Application by Five Estuaries Offshore Wind Farm Limited for an Order Granting Development Consent for the proposed Five Estuaries Offshore Wind Farm

Compulsory Acquisition Hearing 1 (CAH1)

Date: 17 September 2024

Action Points

APFP Regulations 5(2)(f)
Sheet No: Key Plan of 20
SCALE: 1:80,000 PLOT SIZE: A1 DATUM: OSGB 1936 PROJECTION: BNG

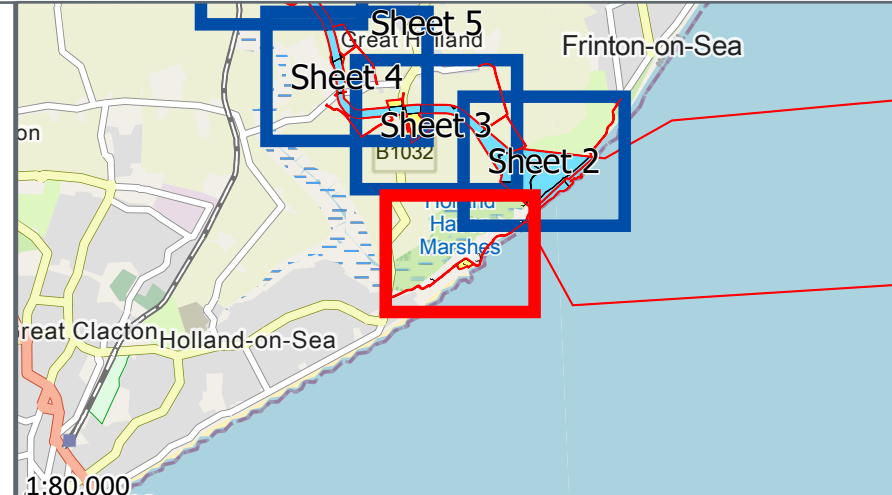
No	Party	Action	Deadline (D)
1	Applicant	Amend the Land Plans [APP-008] to make it expressly clear that the land currently shaded blue is proposed to be the subject of powers seeking both Temporary Possession and Acquisition of Rights powers	D2
2	Applicant	Undertake a review of the Land Plans [APP-008], Book of Reference (BoR) [APP-026], Statement of Reasons (SoR) [APP-030] and draft Development Consent Order (dDCO) [APP-024] to ensure that the depiction of Permanent Rights Acquisition and Temporary Possession powers shown on the Land Plans is consistent with all of the references to Permanent Rights Acquisition and Temporary Possession stated in the BoR, SoR and dDCO	D2
3	Applicant	Provide a clarification for what is stated in paragraph 5.3.3 of the SoR [APP-030]	D2
4	Applicant	Submit an estimate of the onshore landtake for the proposed Five Estuaries Offshore Wind Farm as a standalone development (ie excluding North Falls from the scheme world)	D2
